Subdivision Comments

From: Holly Myers, Environmental Health Supervisor

Date: 01/05/2017

RE: SP-16-00005 DOUBLE K RANCH

CRUSE & ASSOCIATES
PROFESSIONAL LAND SURVEYORS
217 E. Fourth St. P.O. Box 959
Ellensburg, WA 98926 (509) 962-8242
DOUBLE K SHORT PLAT

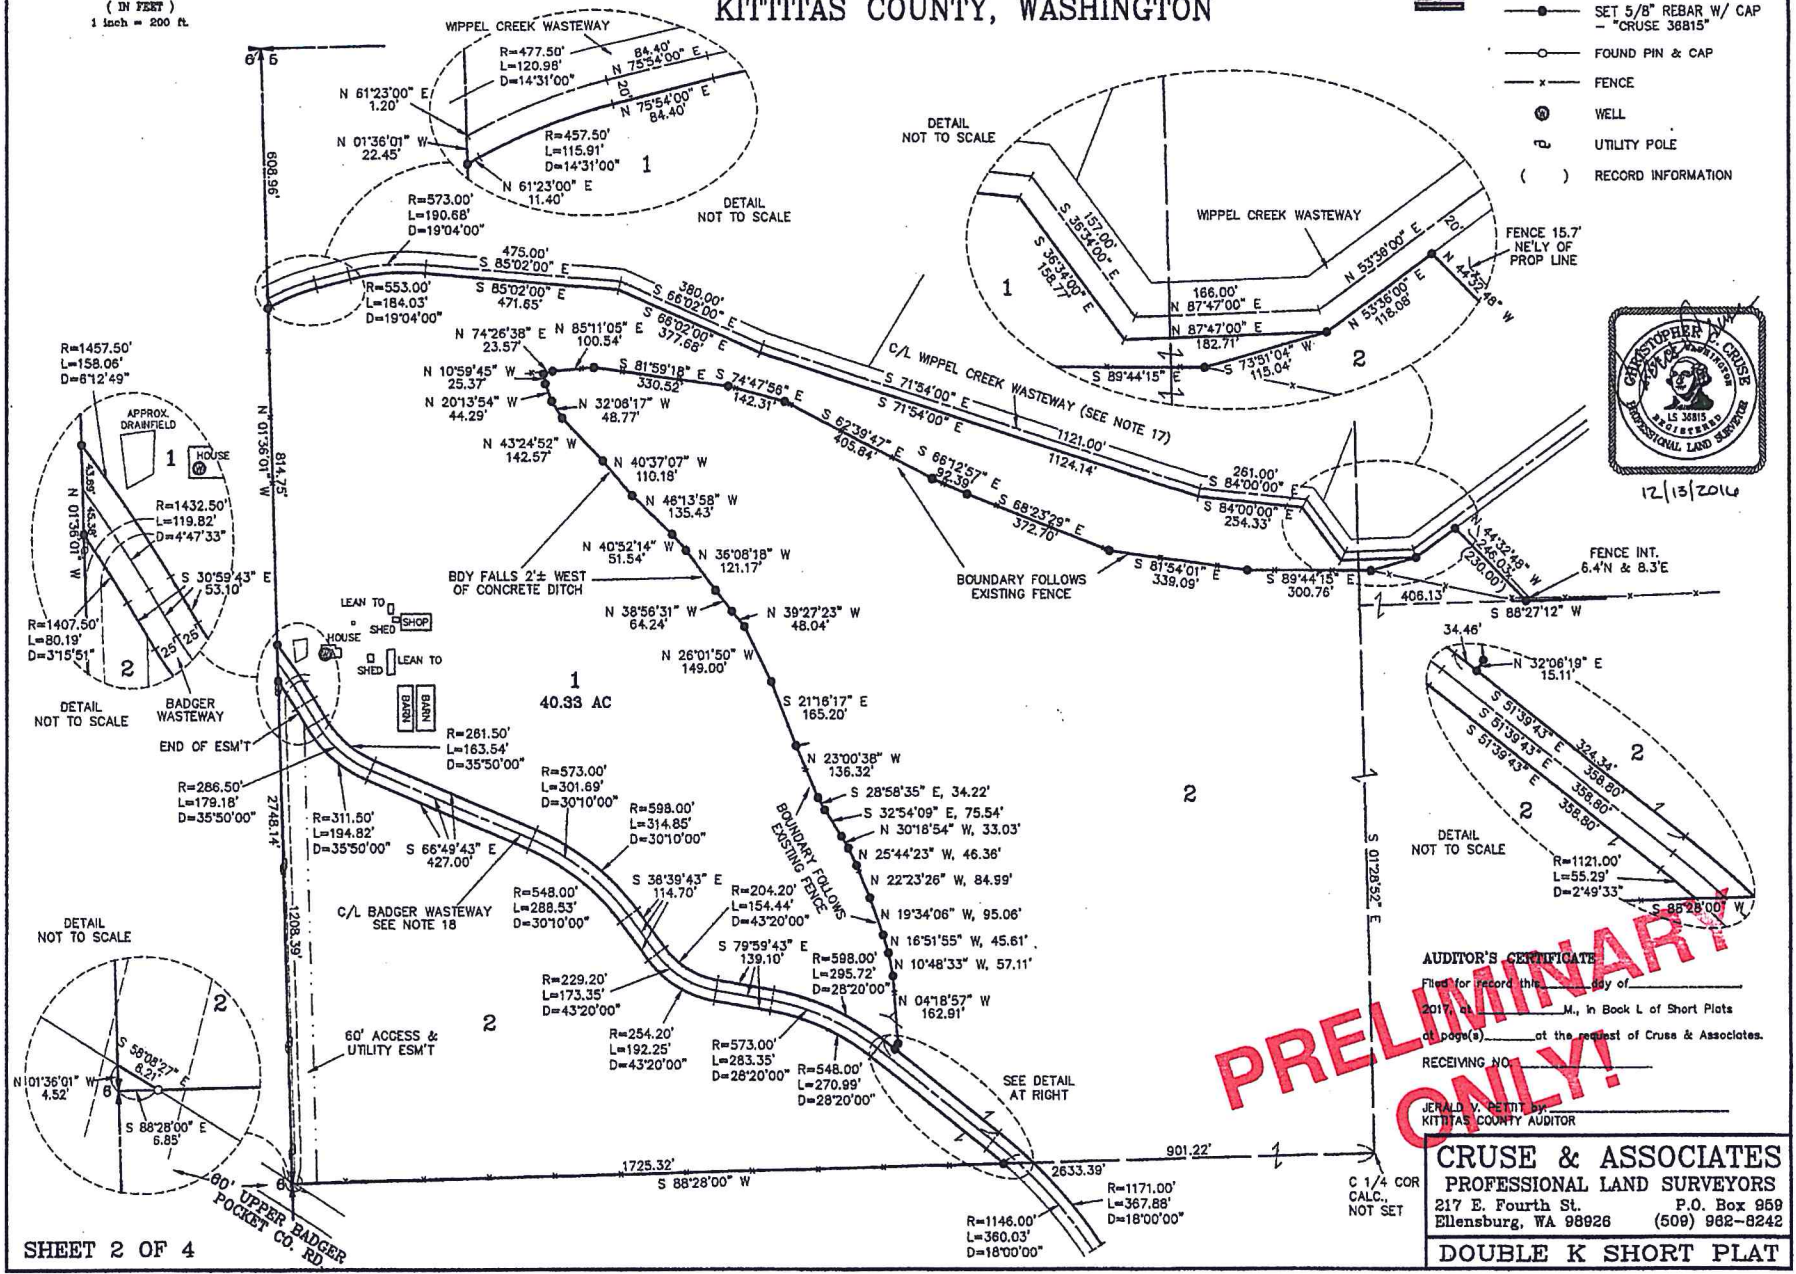
A site map is required to verify that all setback requirements are met with the proposed boundary lines. The map must include all septic tanks, drain fields, wells and boundary lines. Please verify adequacy of the well for a shared well by providing a well log or 4 hour draw down report in addition to a shared well users agreement if the well is intended to supply potable water to both proposed lots.

All wells must meet the distance requirement of 50 feet from the property line, 50 feet from the septic tank and 100 feet from the drain field as per Kittitas County Critical Areas Ordinance 17A.08.25, and KCC Chapter 13. If existing wells do not meet the setback requirement from property lines, the two adjoining parcels nearest the well must enter into a legal, shared well-users agreement. (See Condition A-5)

Well location. The drawings shall be marked with a "w" indicating location of the well and a broken line showing the one hundred foot radius around such. (See Condition A-3)

A-3 The final plat drawings shall be marked with a "w" indicating location of the well and a broken line showing the one hundred foot radius around such."

A-5 All wells shall meet the distance requirement of 50 feet from the property line, 50 feet from the septic tank and 100 feet from the drain field as per Kittitas County Critical Areas Ordinance 17A.08.25, and KCC Chapter 13. If existing wells do not meet the setback requirement from property lines, the two adjoining parcels nearest the well must enter into a legal, shared well-users agreement.
